Our Ref: 19-142**Mr David Gibson (Team Leader)**

RE: S4.55(1A) MODIFICATION APPLICATION TO SSD 14_6848 IN RELATION TO THE STAGE 3B DEVELOPMENT AT LISMORE BASE HOSPITAL

The subject application specifically relates to the approved Stage 3B2 North Tower.

1 Building Elevation - East 3B2
1 : 200

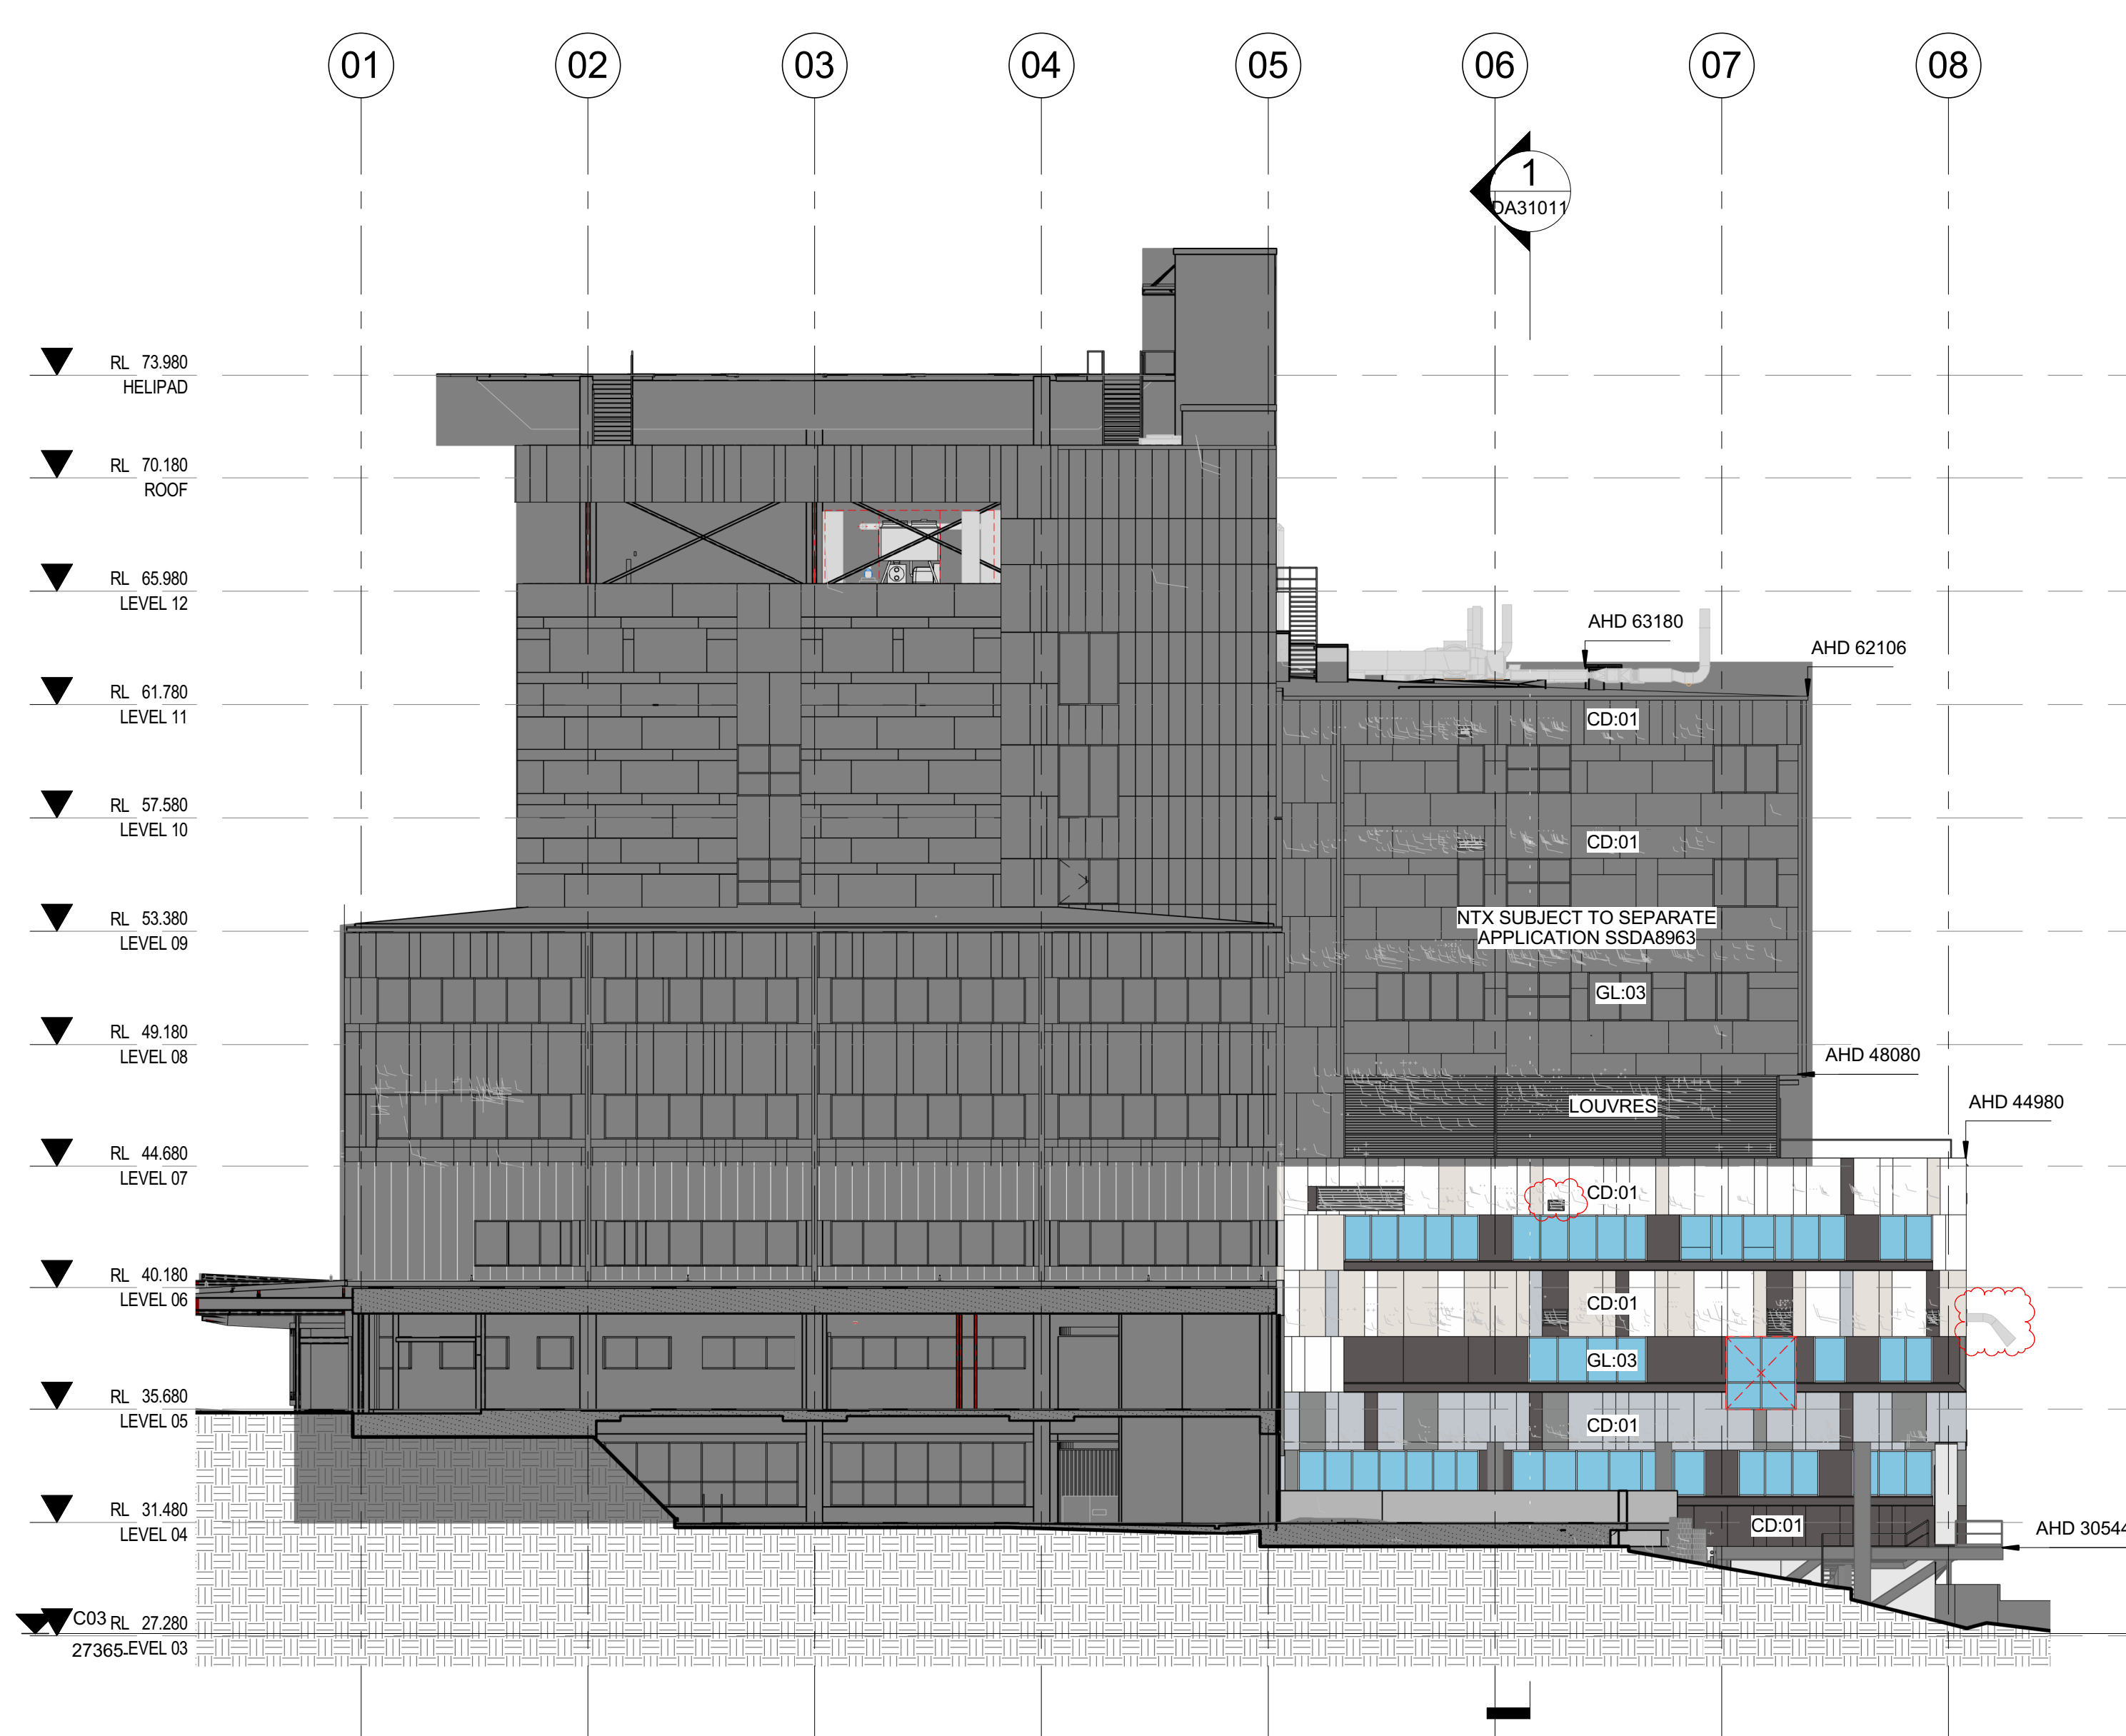
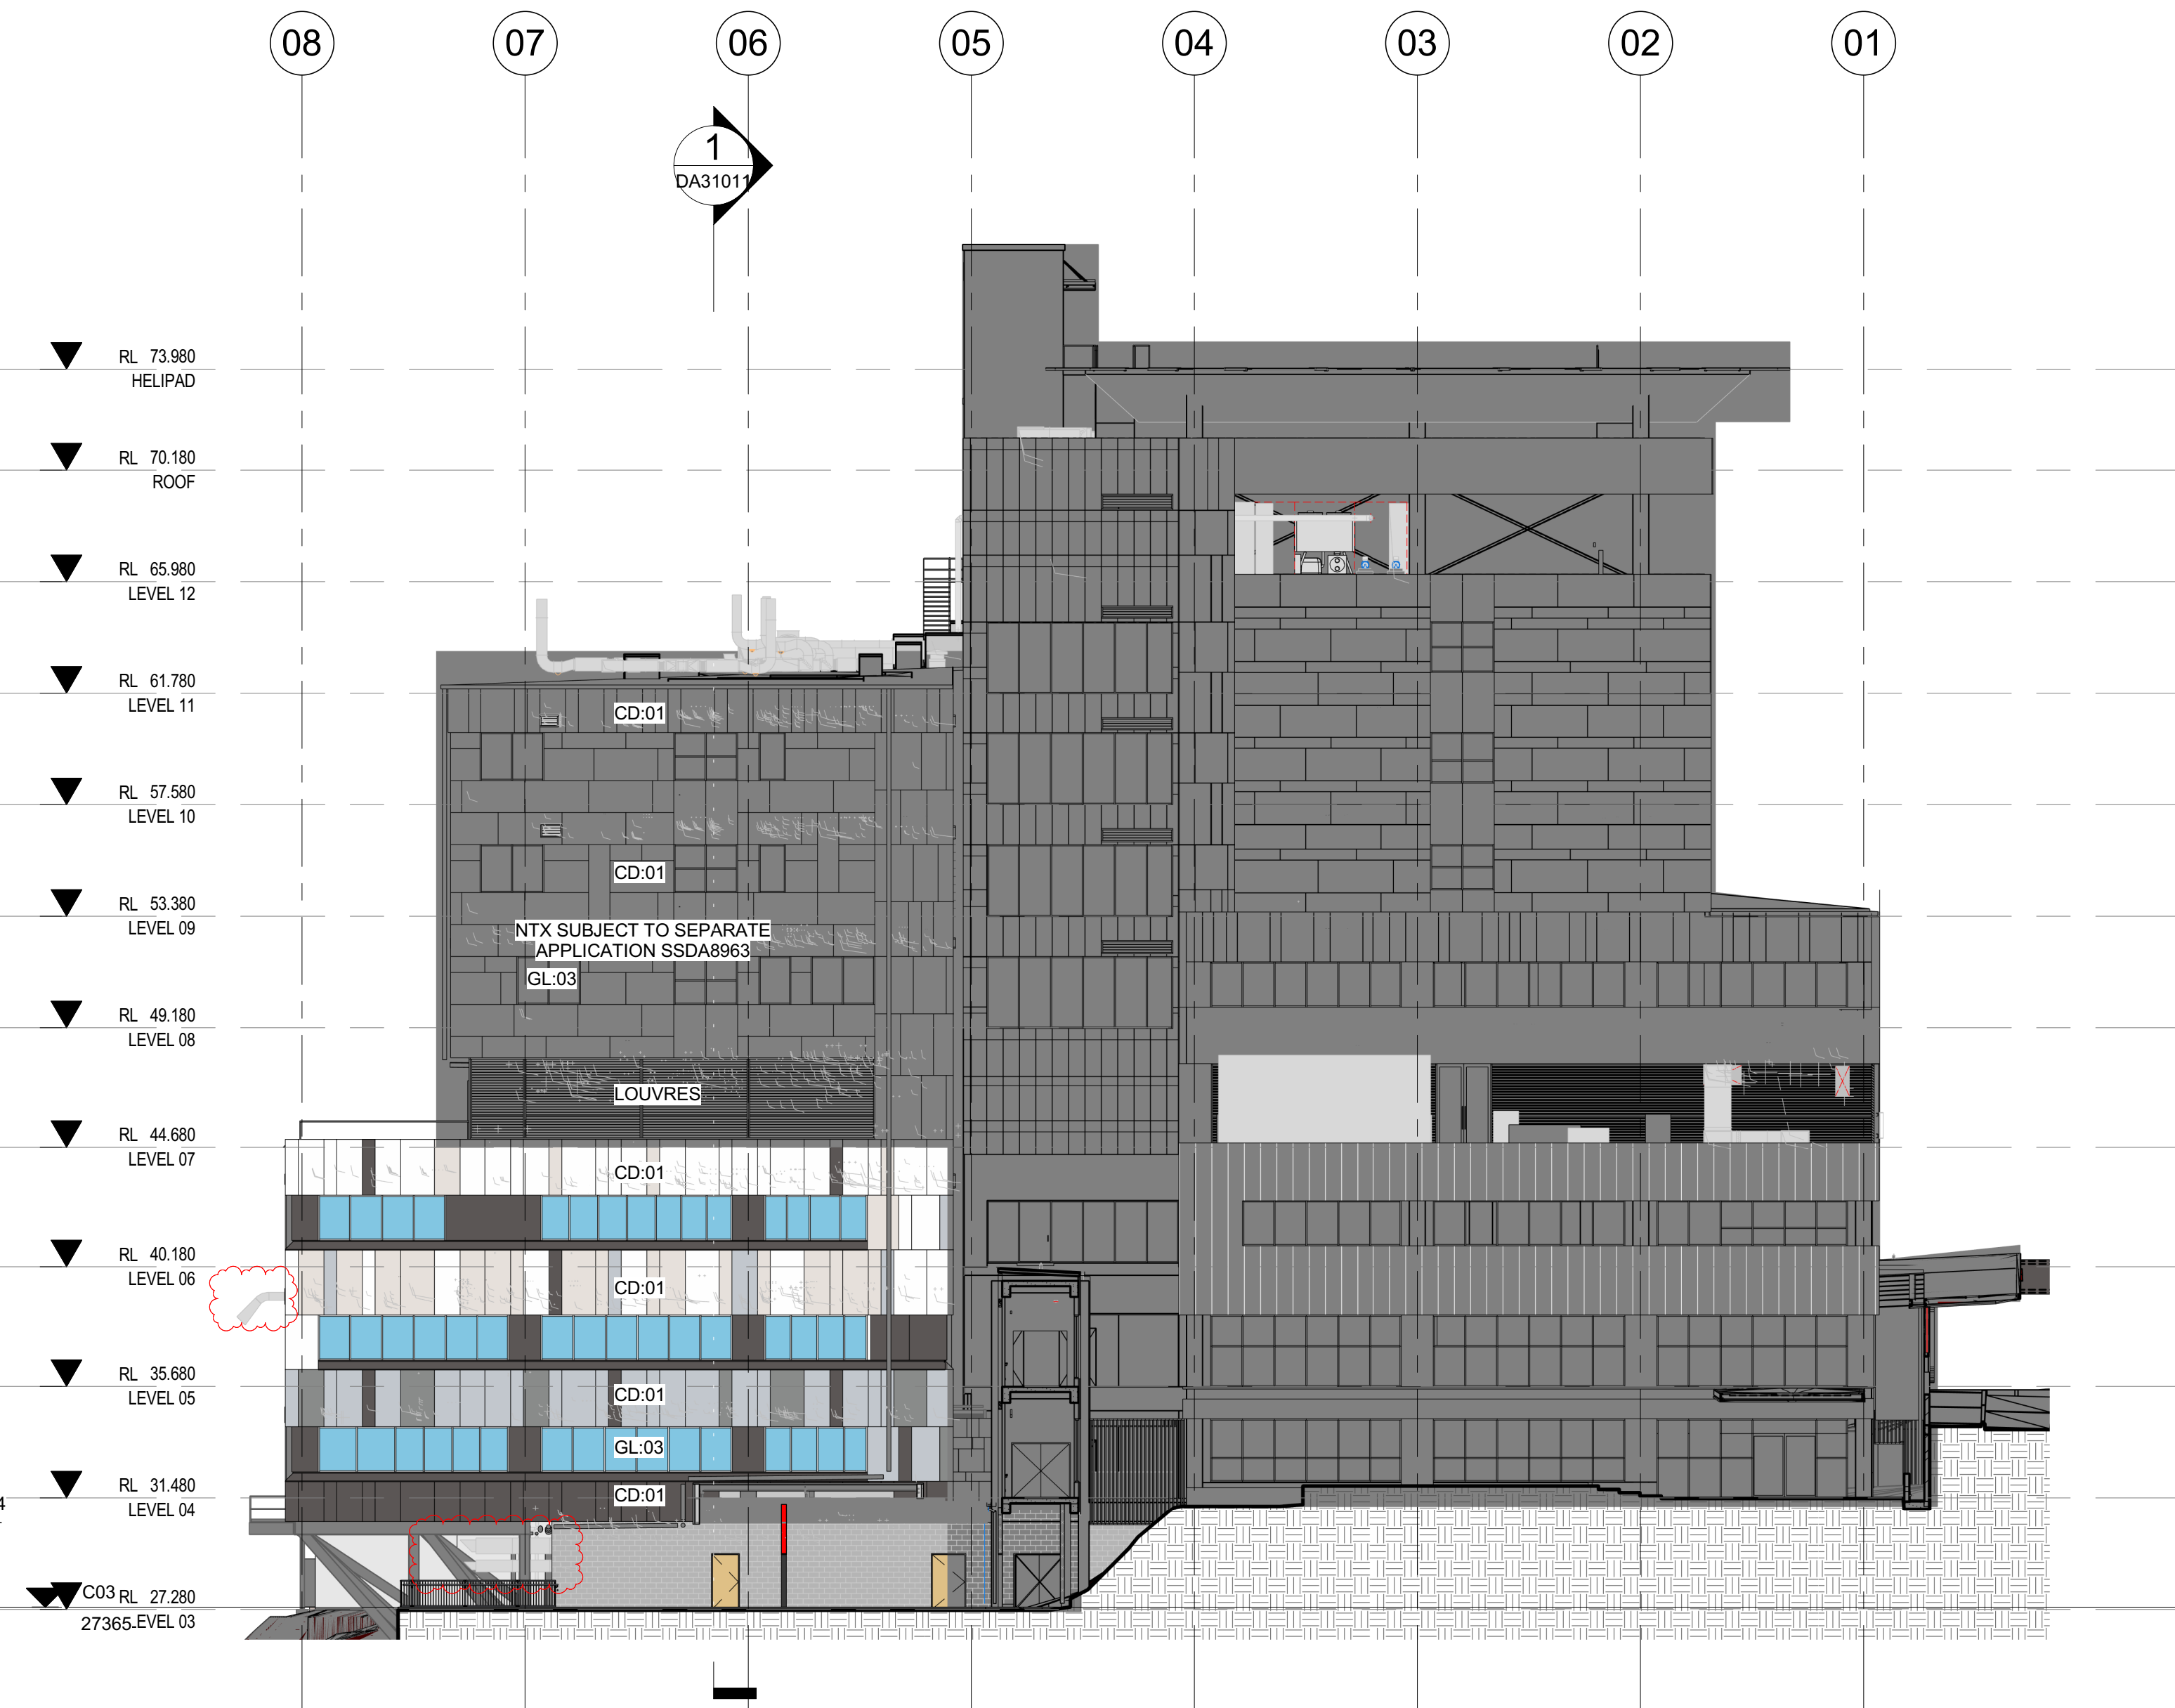
- Eastern and Western Façades: mechanical louvre added at Level 6 (within grid 6) and as above, the quench pipe box location and design has been amended at Level 5 (within grid 8), noting it is also visible from both the eastern and western elevations. Refer to the following comparative elevations for further detail.
